FULL PLANNING PERMISSION

Reference: H05-0586-15 **Date of Decision:** 29th October 2015
Applicant: Sovereign Homes (UK) Ltd
Seagate Hall
Vicarage Lane
Long Sutton
Spalding
PE12 9AF
Location: Off Fleet Road Fleet Hargate Spalding
Description: Erection of 4 bedroom house and detached double garage

Job Ref. 2200-10 Drawing No. 02B,

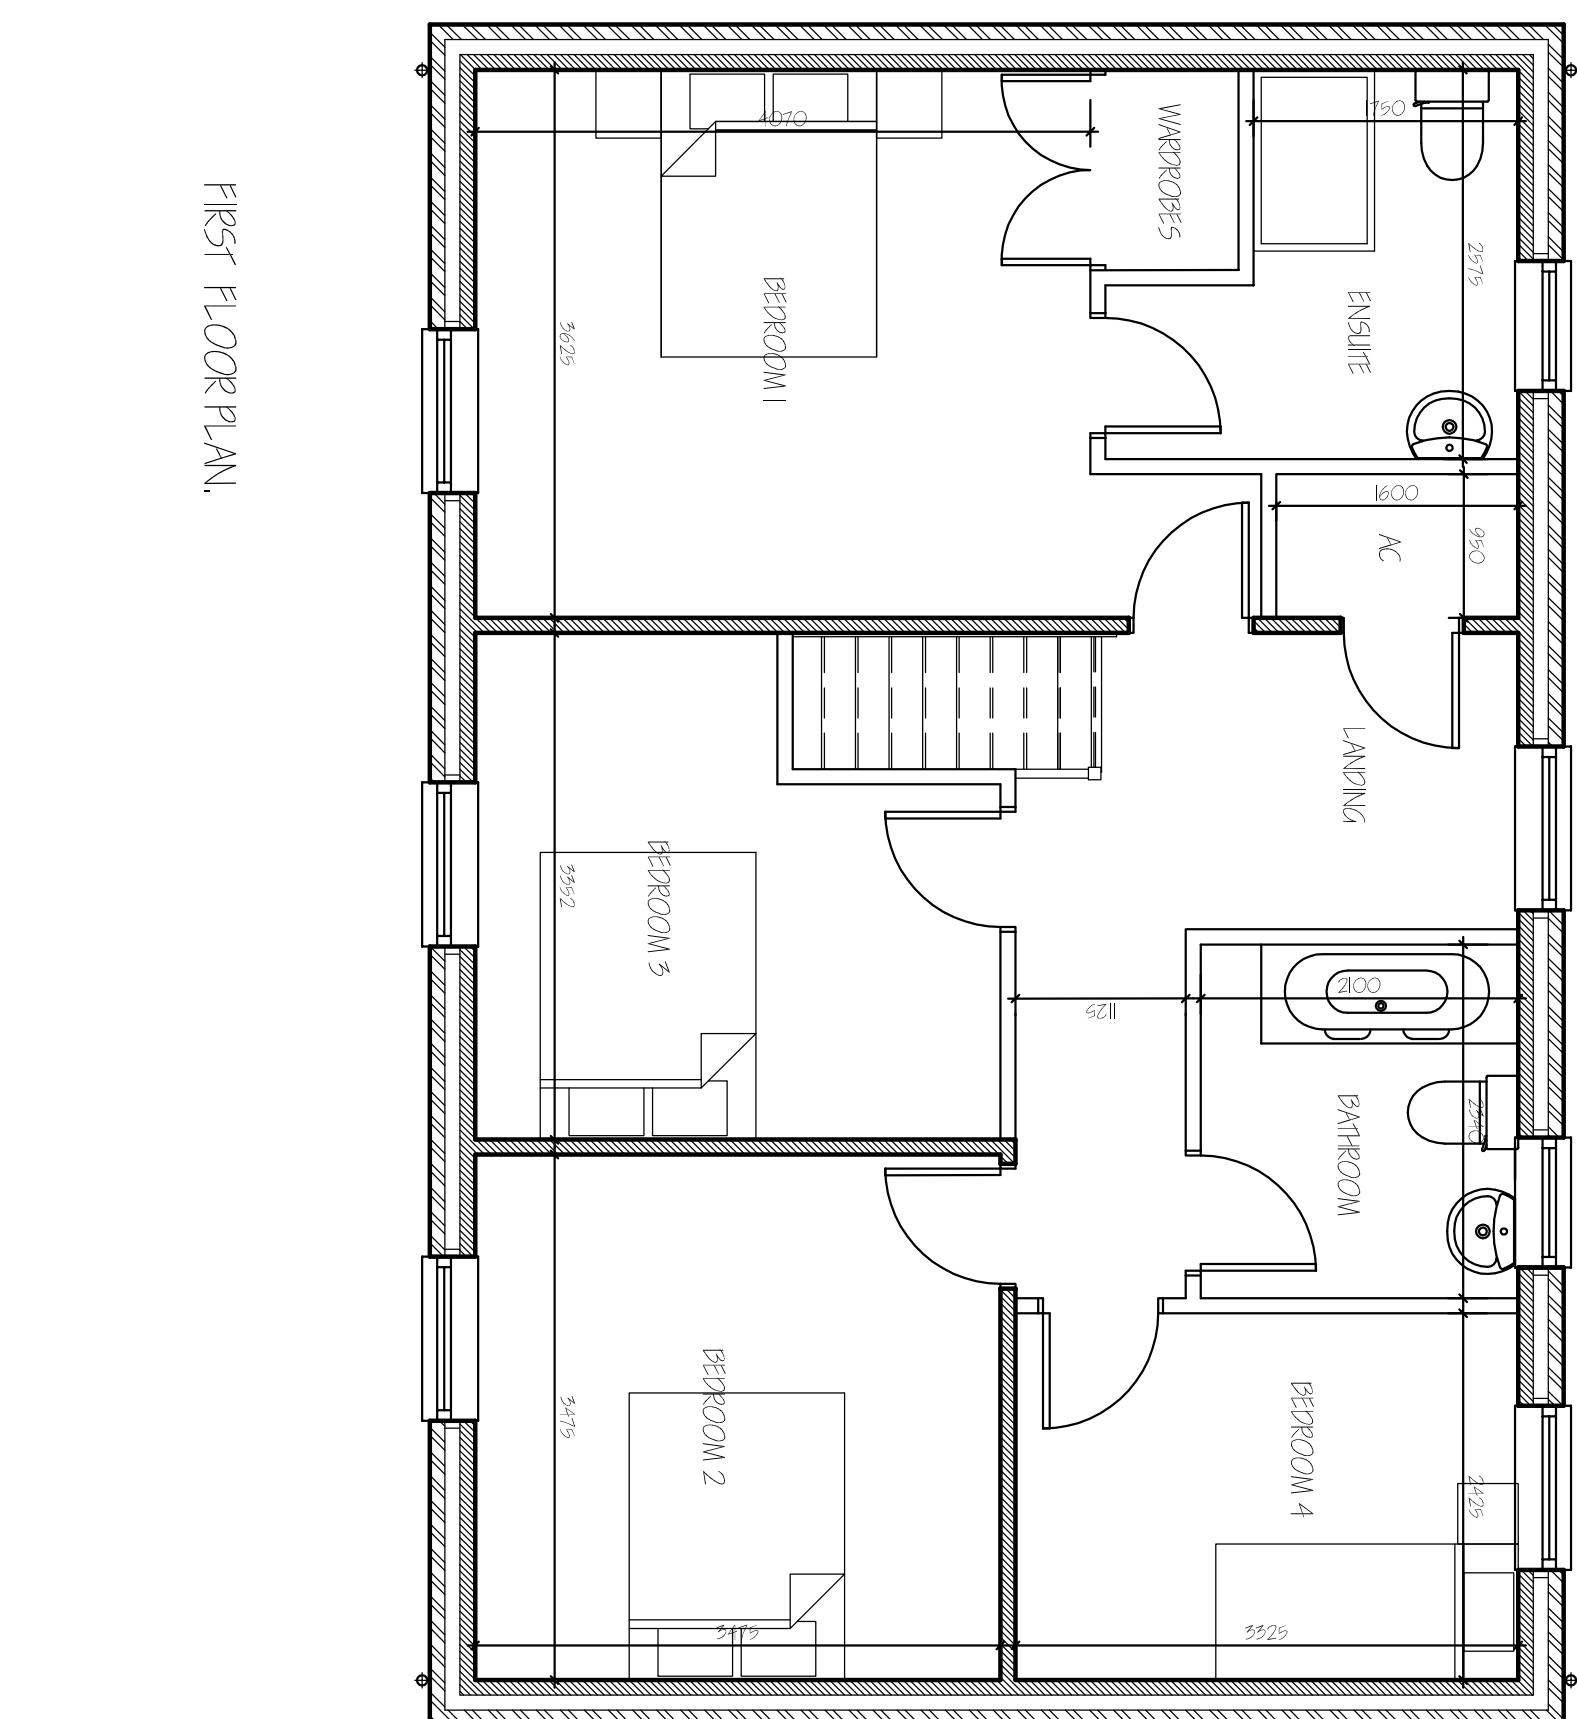
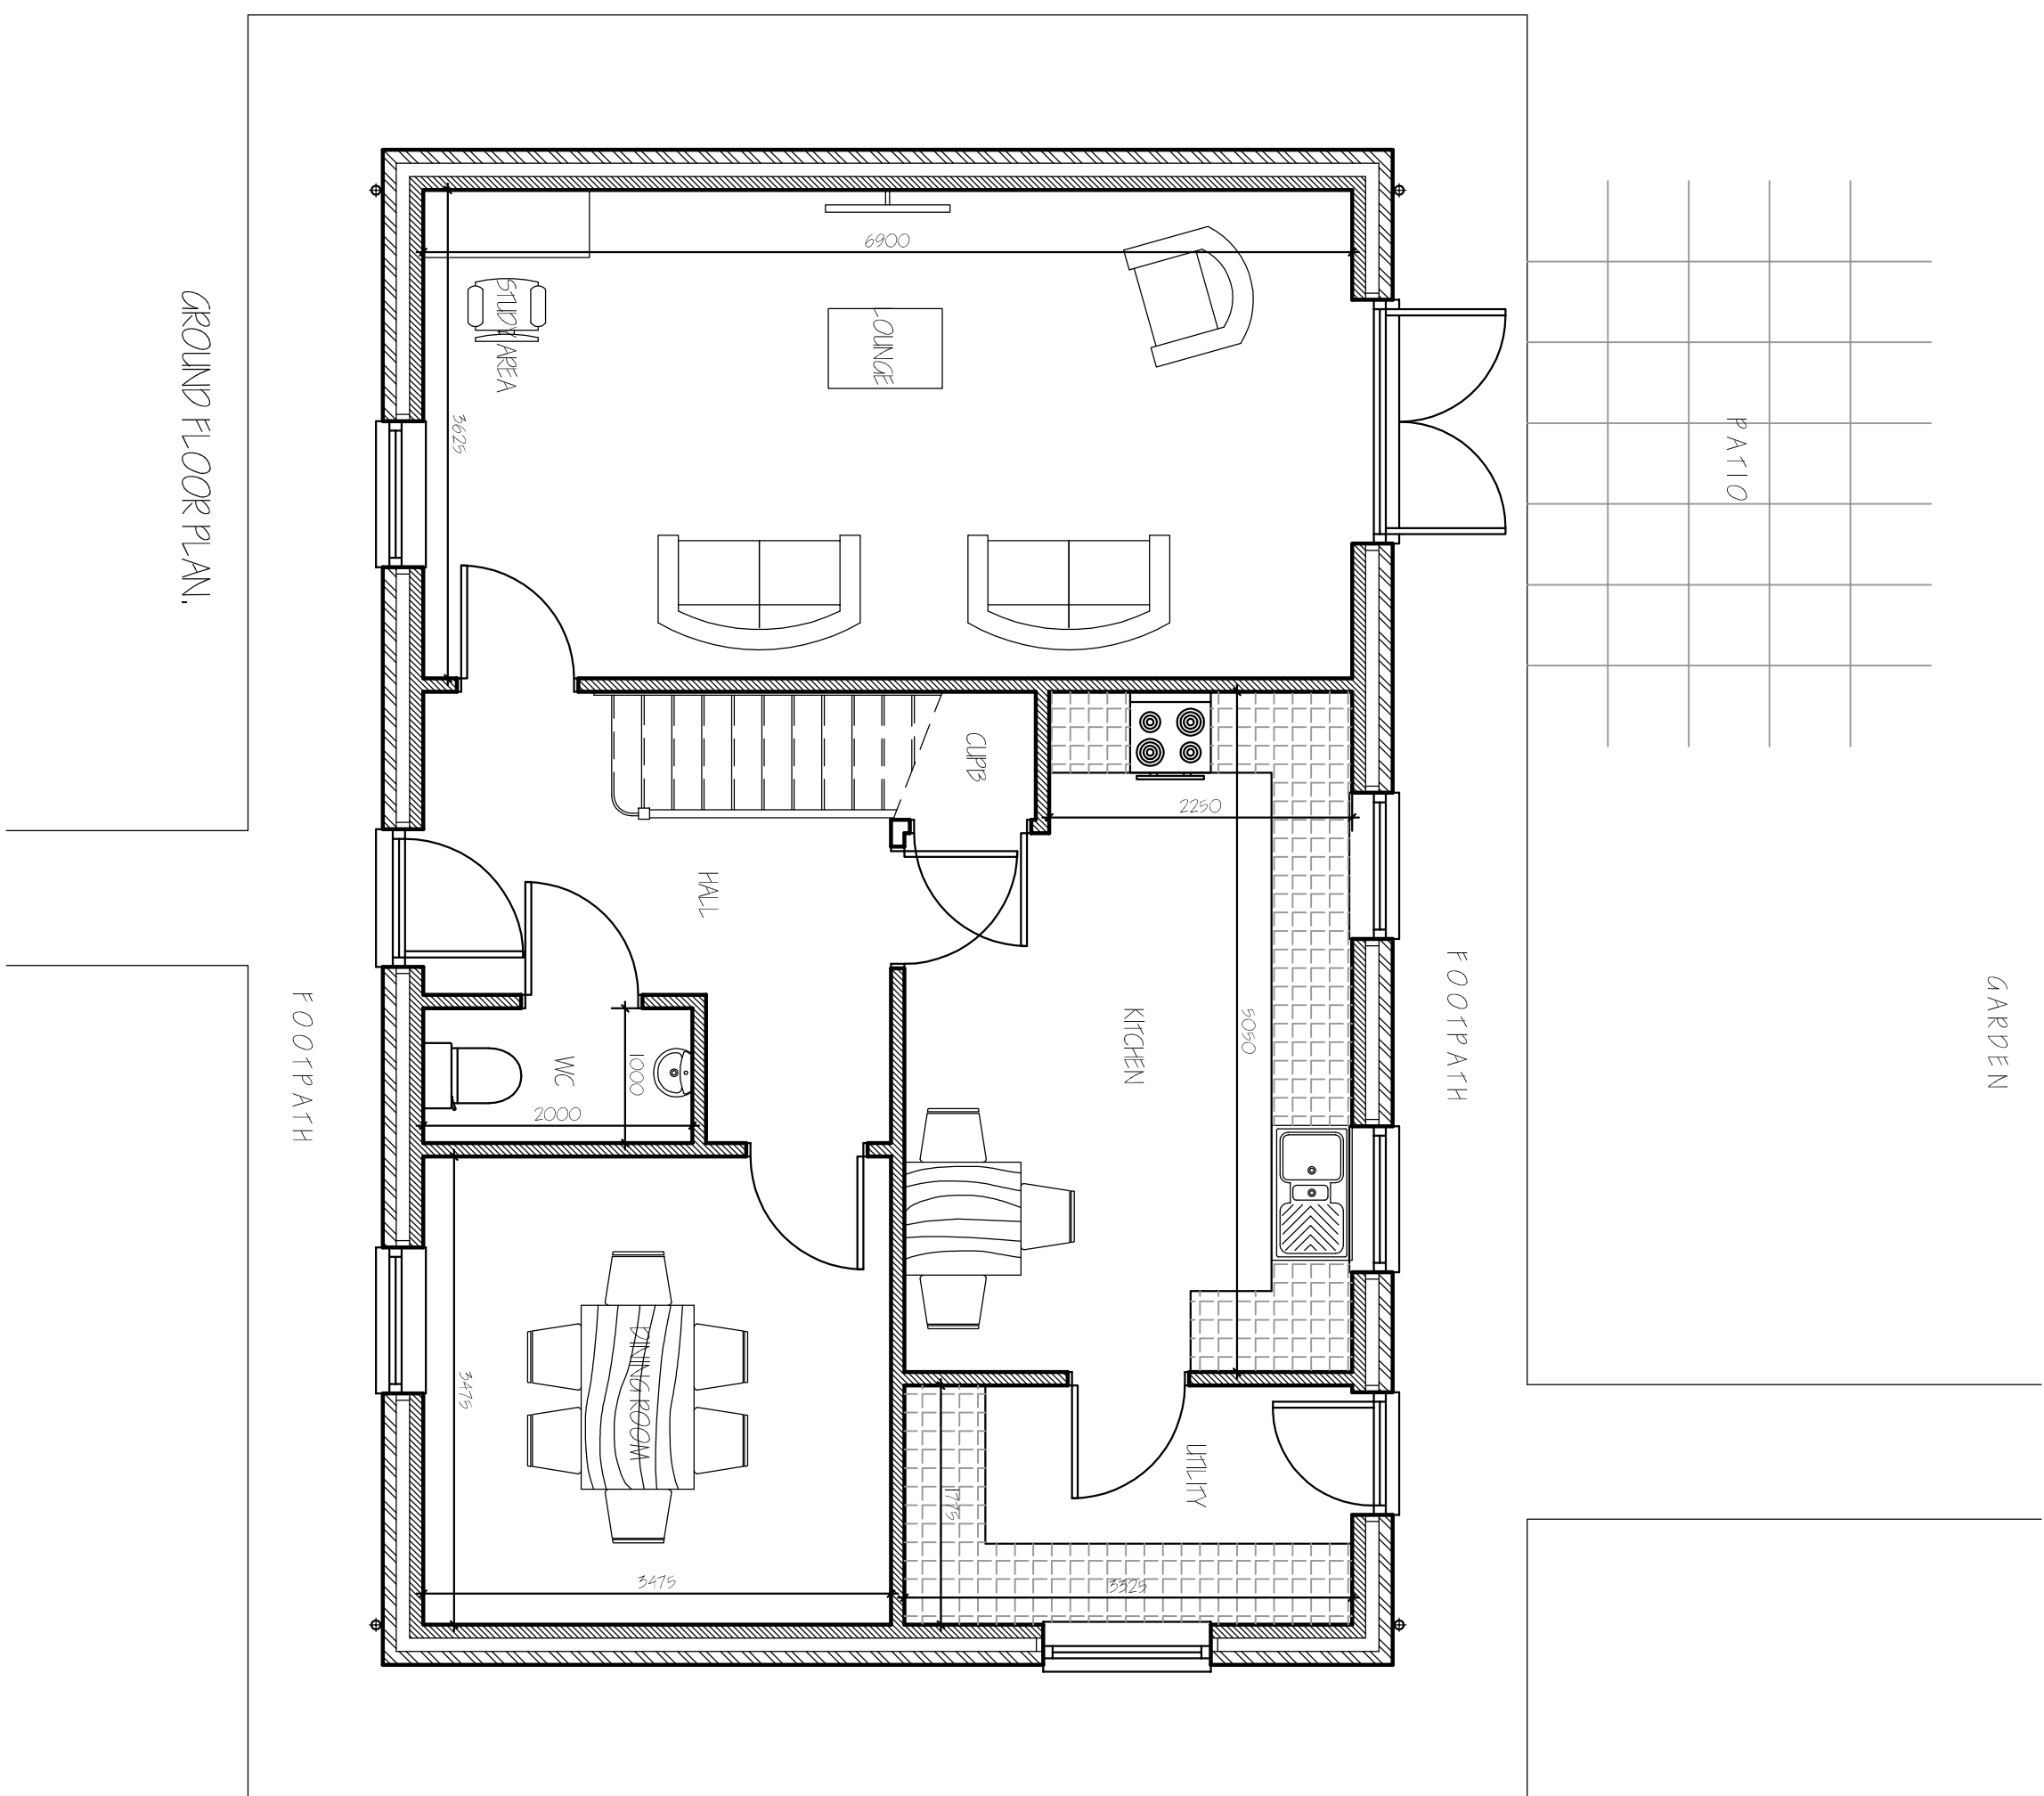
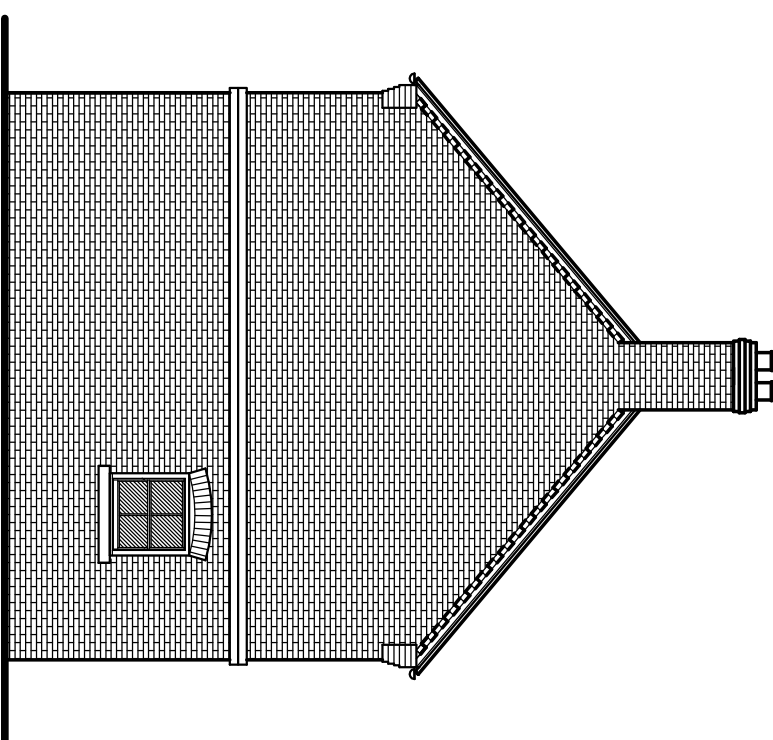
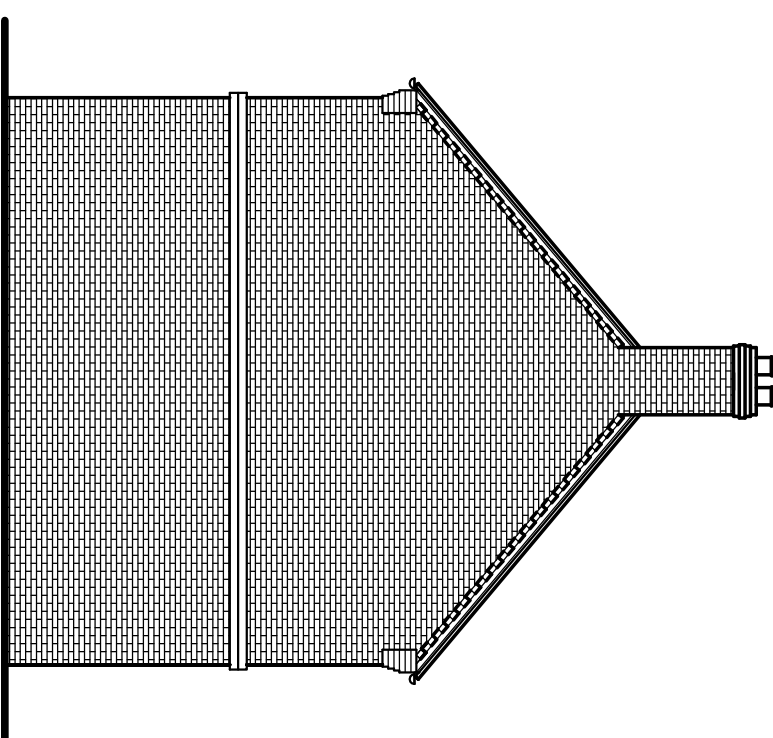
Note: The external brickwork shall be a red stock brick. A variegated brick such as Ibstock Ivanhoe Rural Blend is considered unacceptable in this location.

- 7 The brickwork for the front elevation of the dwelling shall be constructed in English Garden Wall Bond at a ratio of 1:3.

Note: The external roofing material shall be traditional slates or terracotta pantiles.

Note: The windows on the front and side elevations shall be vertical sliding sash.

Note: The new garage doors shall be vertical timber boarded.

- 14 The guttering to the development hereby permitted shall be fixed to the external walls by means of gutter spikes/rise and fall brackets and no fascia boarding shall be used.
